Subject: Request for Advice on Response to Submissions - Modification 7 – Infrastructure consolidation and remediation (SSD-5544-Mod-7) (Sutherland Shire)

CPHR comments on the Response to Submissions - Modification 7 Infrastructure consolidation and remediation (SSD- 5544- Mod-7) (Sutherland Shire)

**FIGURE F3:
FIRE WATER SYSTEM AND
OILY WATER SEWER**

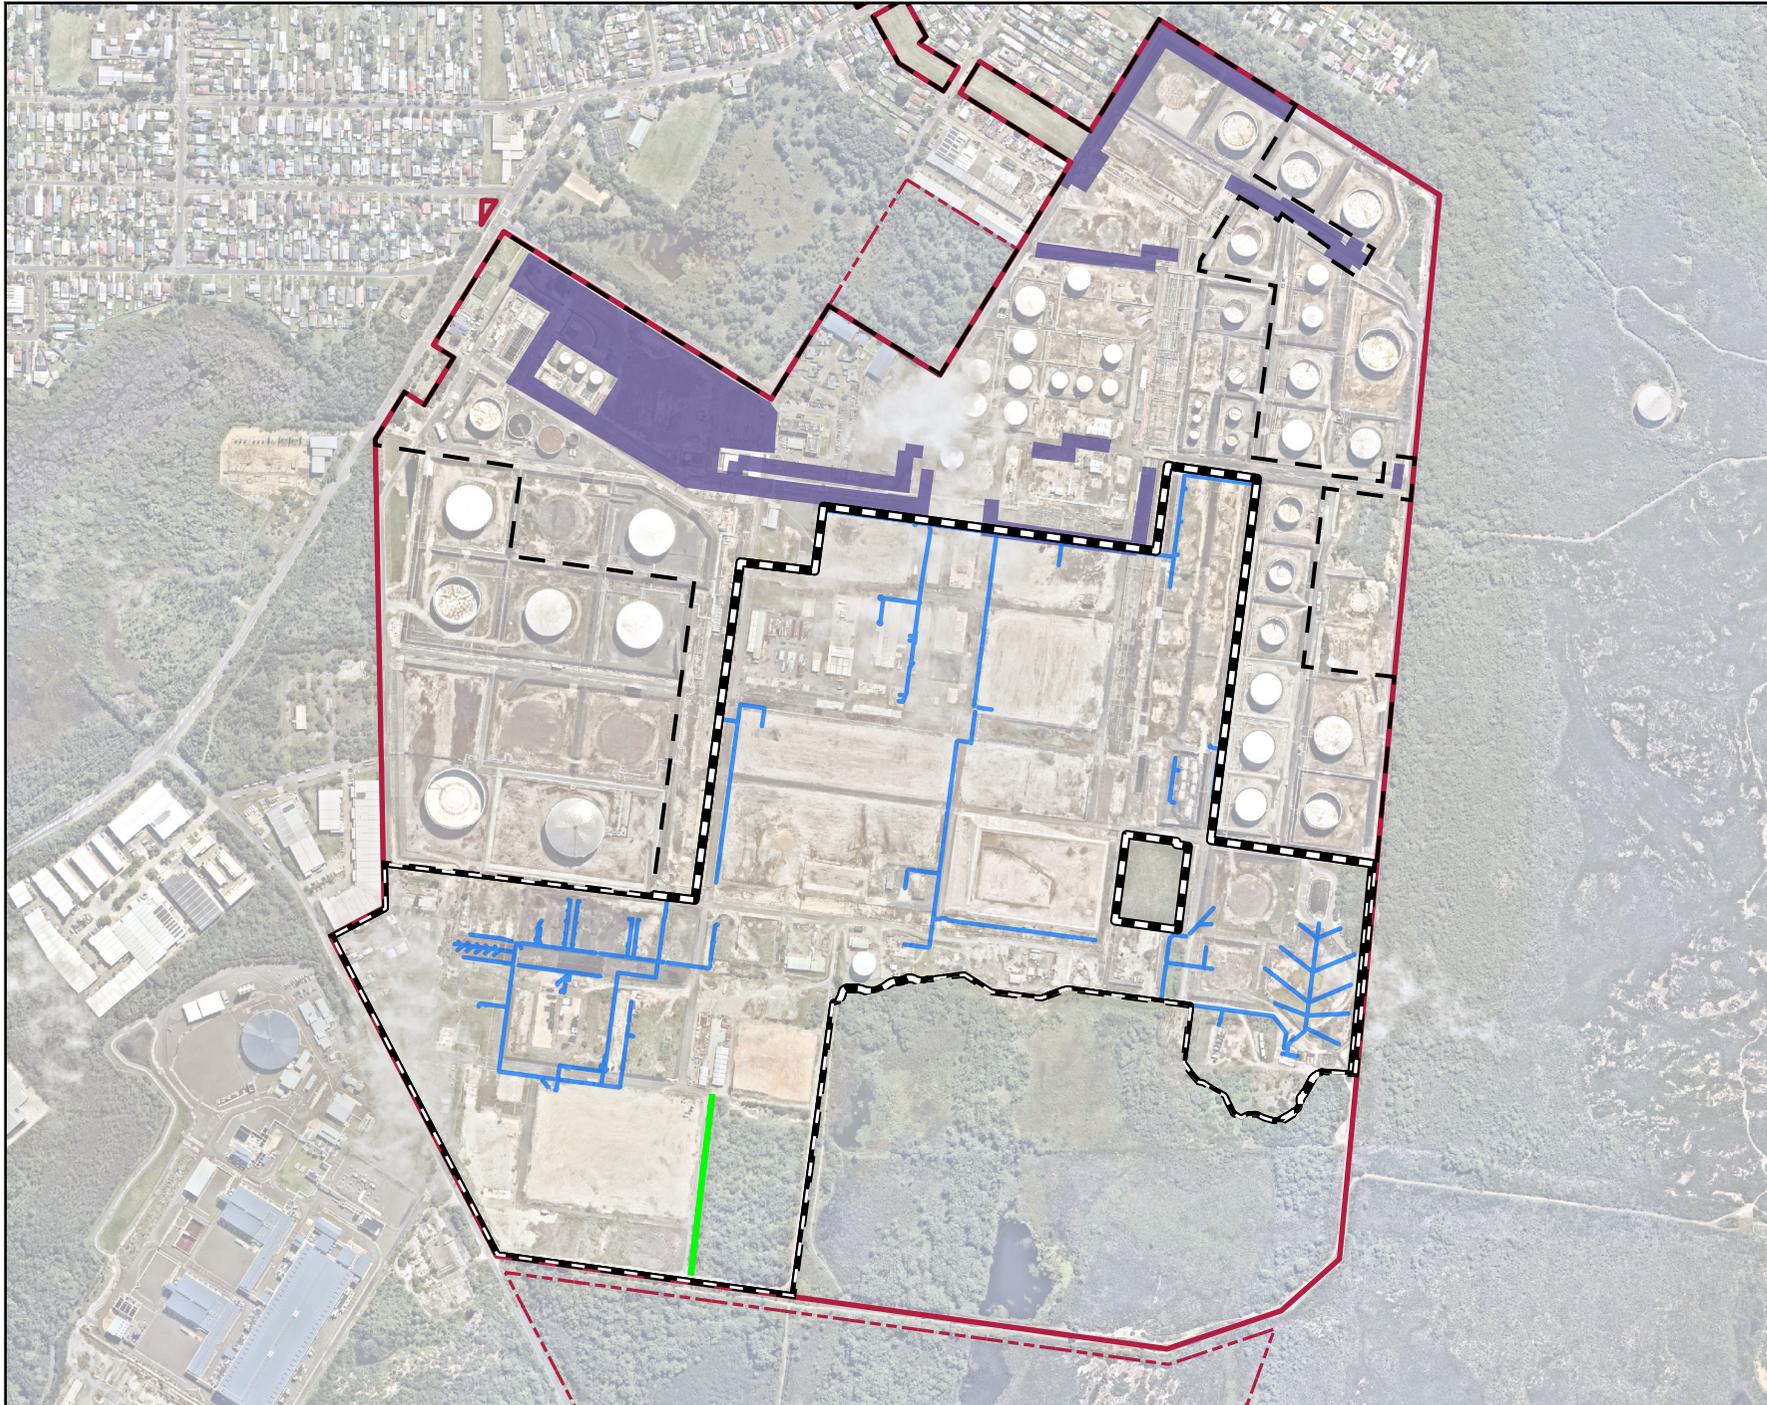
2.	<i>Removal of OWS redirects additional catchment to constrained and sensitive stormwater outlets</i>	<p>Table 5.2 of the SWWFR indicates that an additional 12.2ha of catchment area will be directed to the stormwater system following disconnection of the OWS. This is described as only 4.1% of the existing catchment, however the catchment area studied includes Kamay Botany Bay National Park, which is a significant offsite area in its natural state (see Figure 4.1 of the SWWFR). It is noted that this area would not generate runoff as frequently as the disturbed industrial use area, particularly the roadways.</p> <p>The April 2022 flood event investigated by the Environmental Protection Authority is documented in the Submissions Report, which identified excess freshwater as the likely cause of mangrove decline. This indicates that additional freshwater volumes may pose an issue at the discharge points to Sir Joseph Banks Drive and Quibray Bay.</p> <p>Prior to the removal of the OWS, the Natural Retention Basin (NRB) in Catchment F would not have received runoff from the site therefore both frequency and volume of runoff to this area would be expected to increase.</p> <p>Discharge to natural areas such as mangroves and the NRB is sensitive to frequency and volume of discharge, not just rate of discharge.</p> <p>Recommended action:</p> <ul style="list-style-type: none"> • Revise the SWWFR to address the impacts of additional runoff frequency and volume to natural areas including the NRB, the mangrove area in Quibray Bay and Towra Point Nature Reserve.

3.	<i>Limited information provided to demonstrate suitability of proposed OSD</i>	<p>The SWWFR proposes to compensate for the additional runoff from the site by providing OSD. Three forms of OSD are proposed:</p> <ol style="list-style-type: none"> 1) Detention in the previous CLOR pipeways and a pipeway in Catchment B. The pipeway in Catchment B has previously been used for transfer of hydrocarbons and may contain asbestos. 2) Detention in a new open channel downstream of the Refining Process Improvement Project (RPIP) Mountain area which is proposed to be removed. 3) Detention within the bunded structures previously connected to the OWS with proposed slow release to stormwater systems including one redirected to the NRB. <p>Many of the existing bunded areas do not have sealed bases and were used for the temporary retention of contaminated runoff prior to pumping to the OWS. Therefore, it is likely that these areas will contain contaminated soils and their use as detention basin will not be suitable. Contaminated soil cannot be removed without removal of the bund walls therefore the viability of this solution is questionable. The bunded areas are proposed to be discharged primarily to new stormwater pipework and then to the NRB. This area currently only receives water from natural areas. The impact of these potentially contaminated flows on the natural receiving environment has not been considered.</p> <p>Recommended actions:</p> <p>The following recommended actions relate to each of the three proposed forms of OSD.</p> <ol style="list-style-type: none"> 1) Demonstrate the suitability of the pipeways for OSD and how stormwater will enter and leave these pipeways. 2) Demonstrate how the new channel will be configured to provide detention and address the likelihood of it being contaminated by leachate from the remaining stored waste material. 3) Consider the impact of potentially contaminated flows from the bunded areas on the natural receiving environment. It is recommended that this OSD option be no longer pursued unless it can be determined that there is no contamination within the bunded areas.

<i>Extent and Timing</i>	Prior to Determination
6.	<i>Details are required on the proposed oily water storage and pump facility in Catchment F</i>	<p>The SWWFR proposes a new oily water pump and storage facility at the junction of Catchments B and F. The requirements, purpose and sizing of this facility is not explained.</p> <p>Recommended action:</p> <ul style="list-style-type: none"> • Provide details on the need for the oily water pump and storage, the degree of site disturbance required for its installation and how water will be taken to and from this infrastructure.
	<i>Extent and Timing</i>	Prior to Determination
